**Subject:** 2020/90480 Parkwood Methodist Church, Parkwood Road, Longwood, Huddersfield, HD3 4TT  
**Date:** 08 November 2020 14:54:32

Thankyou for your consultation to the Ancient Monuments Society ( which is concerned with listed buildings of all ages and all types ).

Proposed Plans & Elevations

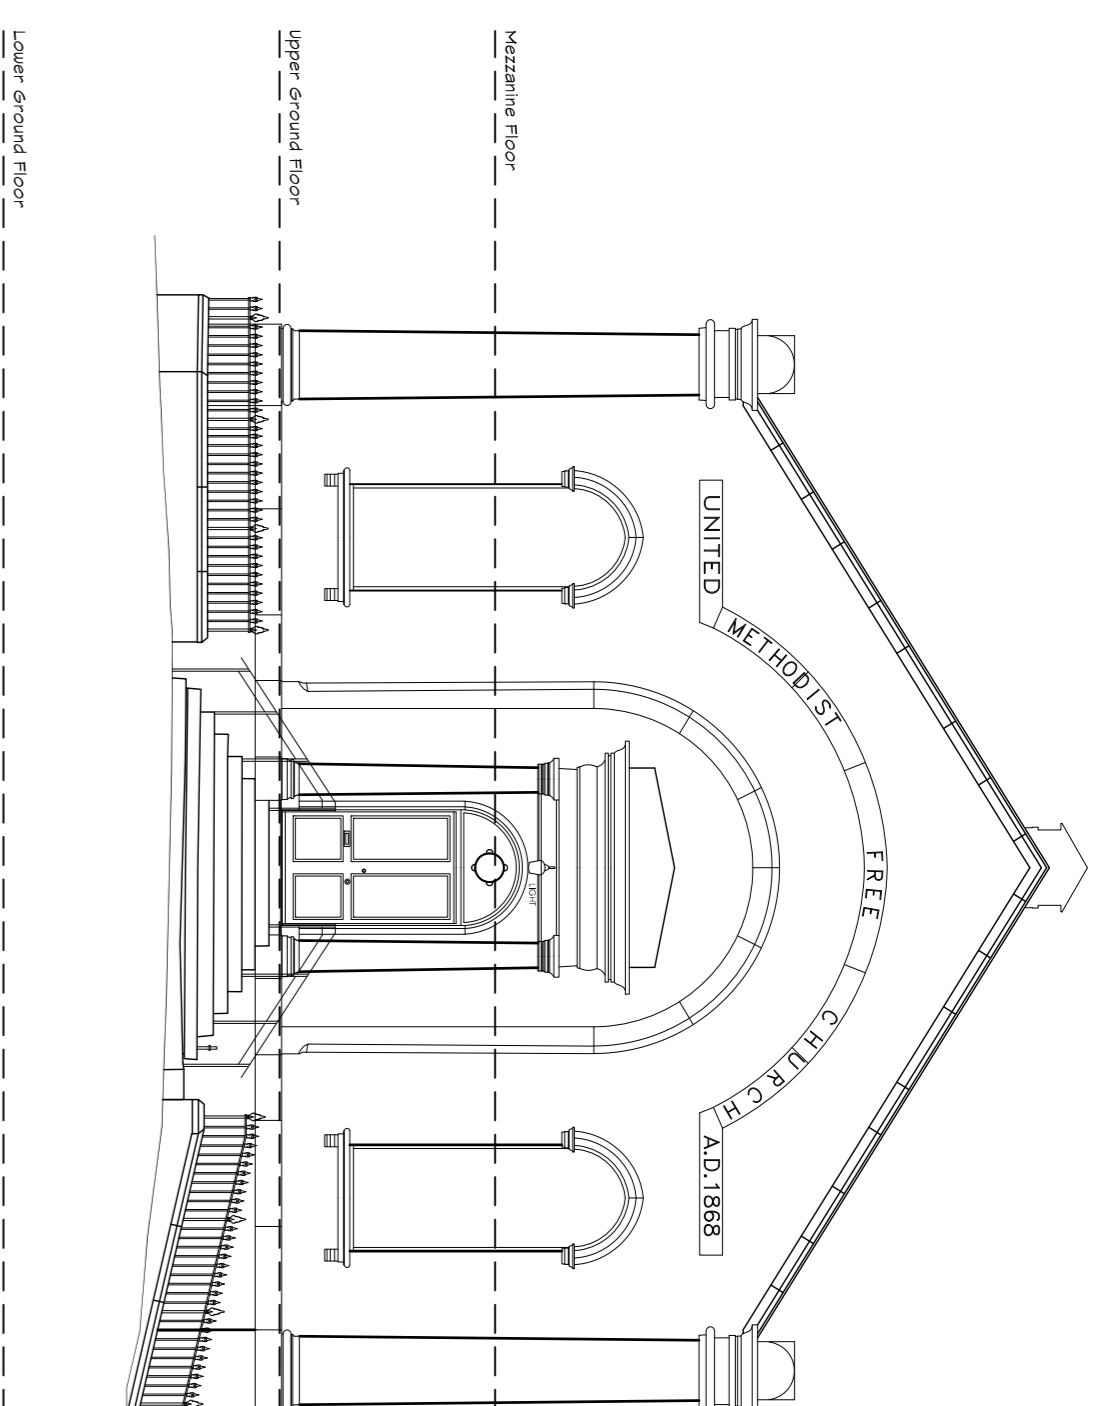
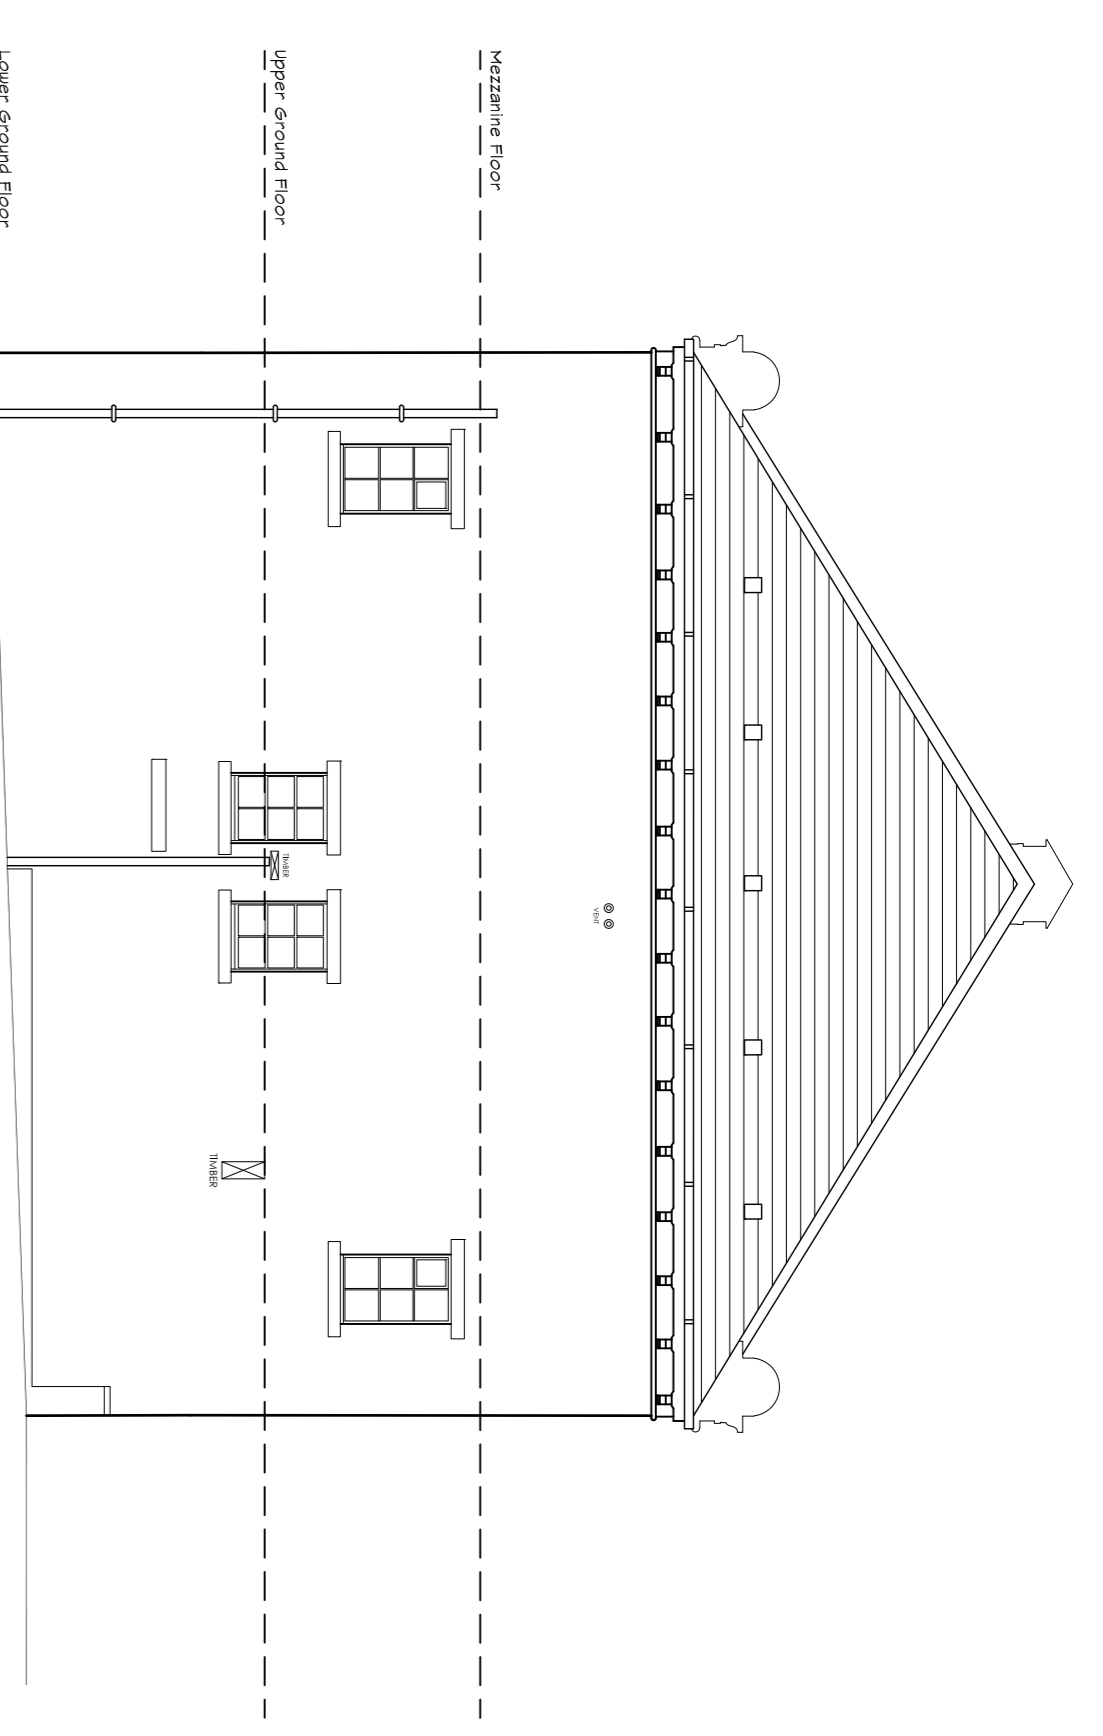
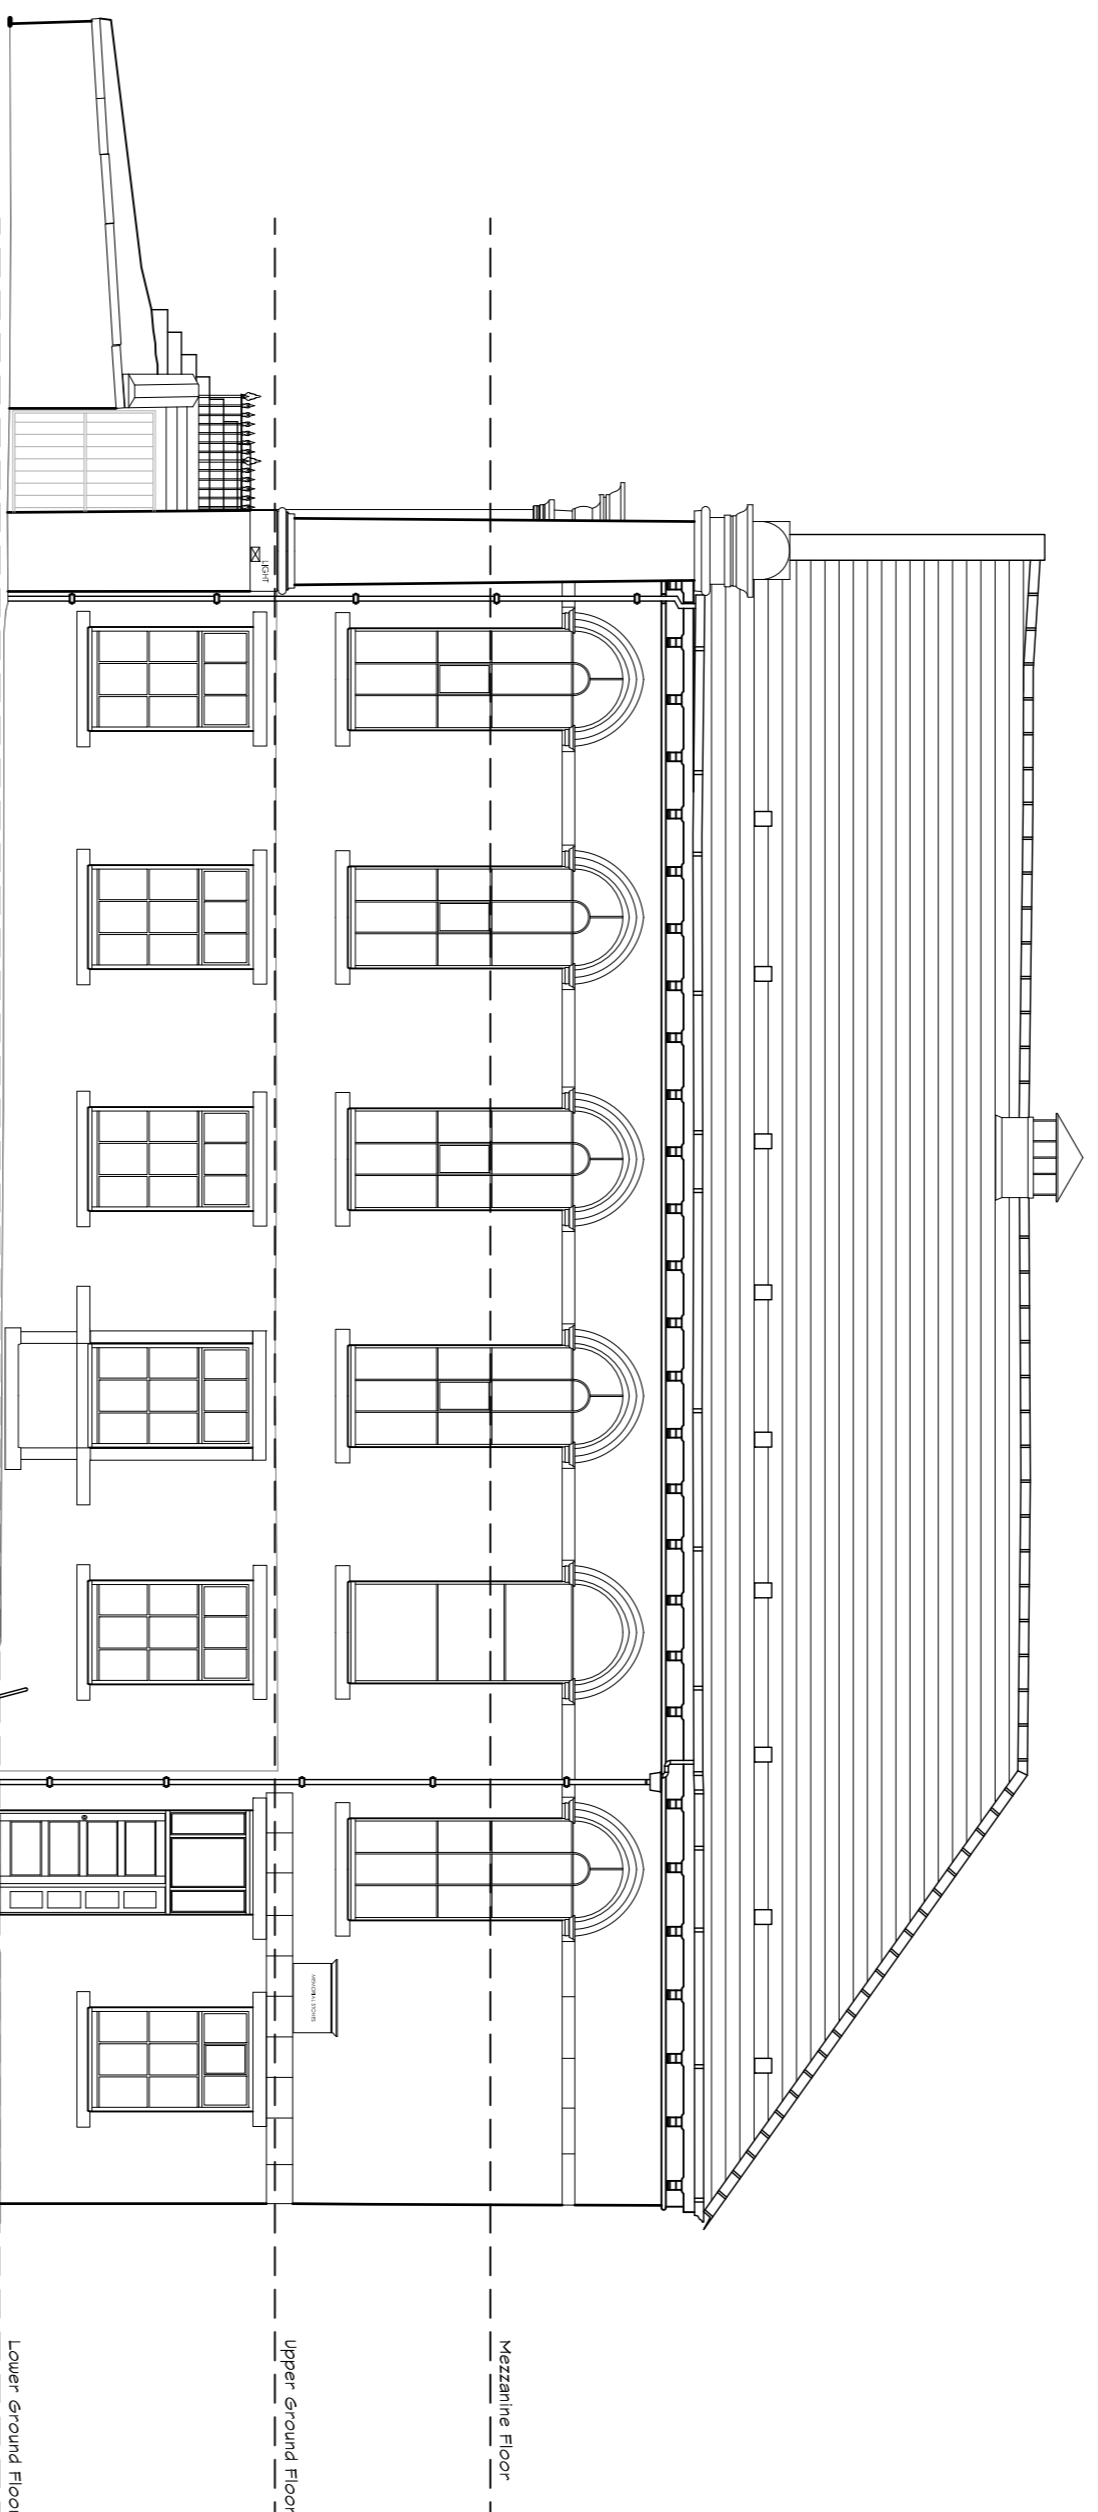
This gutting is then compounded by the insertion of a new suspended floor which, along with the asymmetrical, heavily cellular, subdivision of the interior, will destroy any sense of the present openness. The floor will also cut across the substantial windows and be clearly visible from the outside.
